CITY OF ALBUQUERQUE
PLANNING DEPARTMENT
DEVELOPMENT REVIEW BOARD

Project# 1007140
13DRB-70672 EXT OF MAJOR PRELIMINARY PLAT

Project# 1007140
12DRB-70177 EXT OF MAJOR PRELIMINARY PLAT

MARK GOODWIN AND ASSOCIATES, P.A. agent(s) for JTH, LLC request(s) the above action(s) for all or a portion of Lot(s) 2A, **JUAN TABO HILLS UNIT 3B** zoned RD-SU1, located on JUAN TABO BLVD BETWEEN MONACHOS RD AND TIJERAS ARROYO containing approximately 9.54 acre(s). (M-22)

TITLE: **JUAN TABO HILLS UNIT - 3B  
 GRADING & DRAINAGE PLAN**

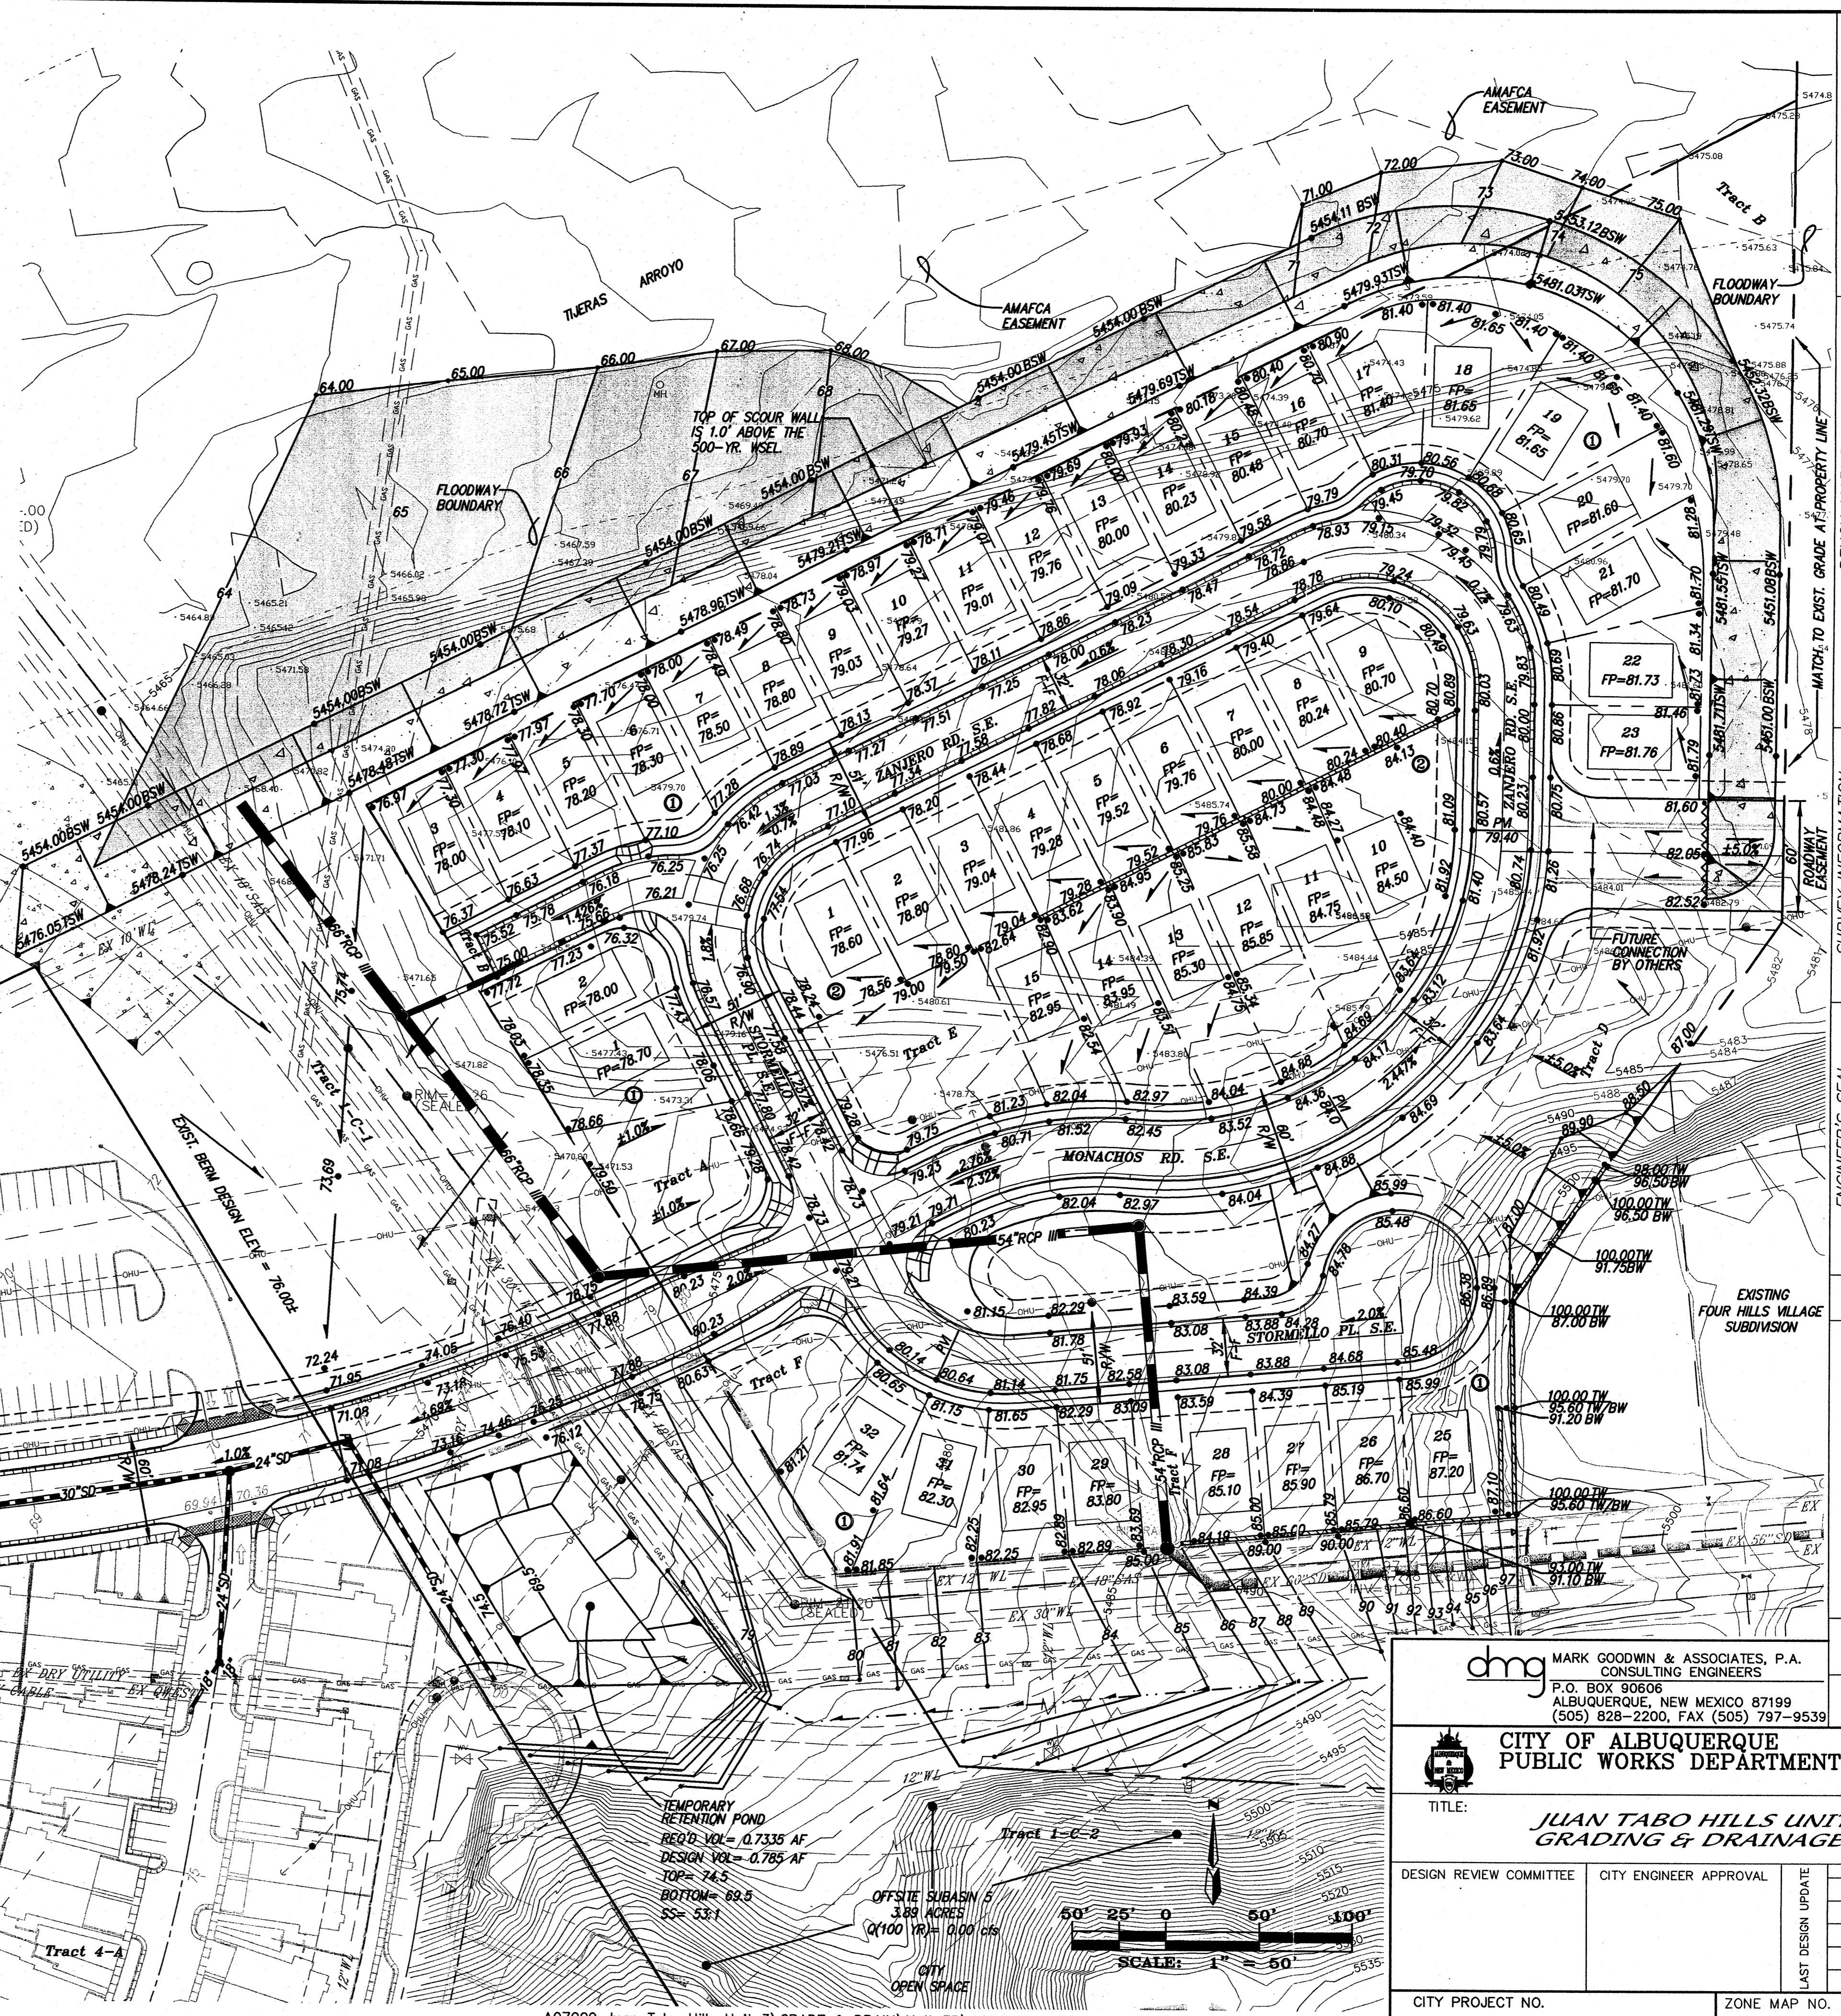
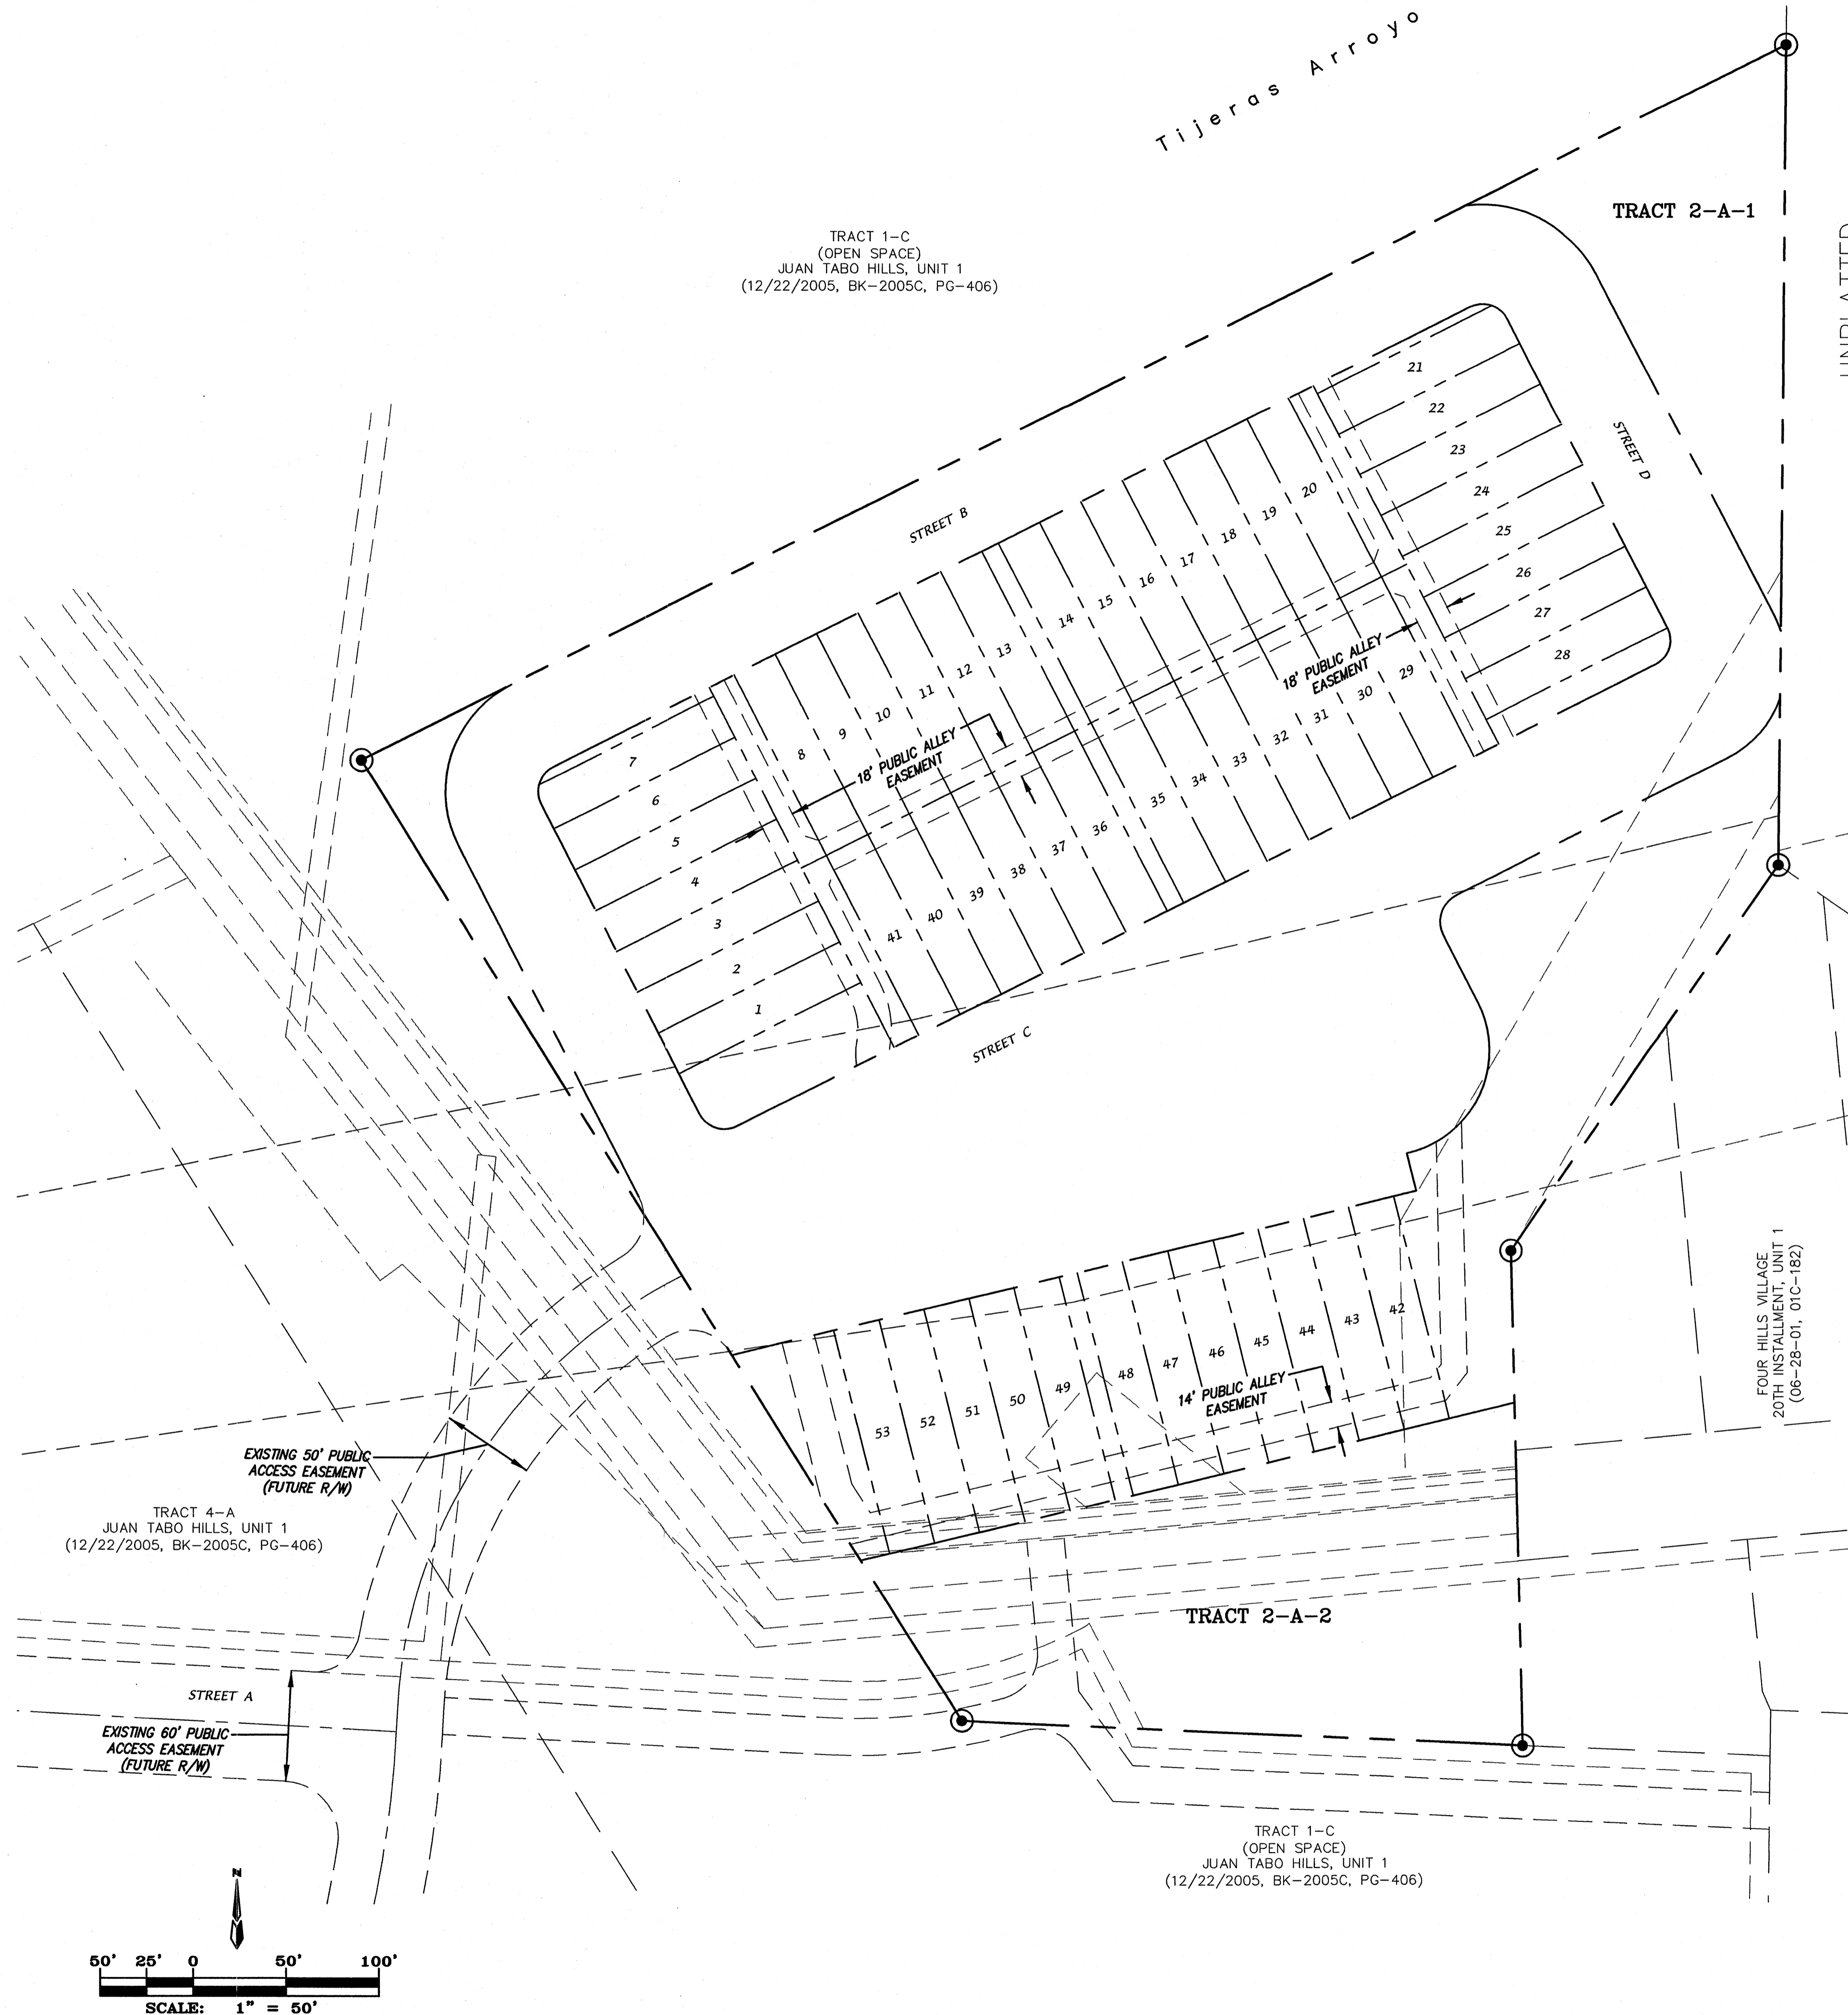
3. It will be necessary to have current and effective vacation approvals as needed and previously approved for the proposed plat.
4. An amended grading and drainage plan for Unit 3-B, Unit 3A and Tracts 1-C-1 and 1-C-2 must be submitted and approved by the Development Review Board.

5. The comment letter from City Hydrology dated May 29, 2012, Juan Tabo Hills Unit 3A Grading and Drainage Plan should be satisfactorily addressed

7. Keyed Note 25 notes there is a 51 foot wide Public Access Easement granted to the City of Albuquerque for Tract A which may interfere with the scour wall shown on the Grading and Drainage Plan that needs to be addressed.
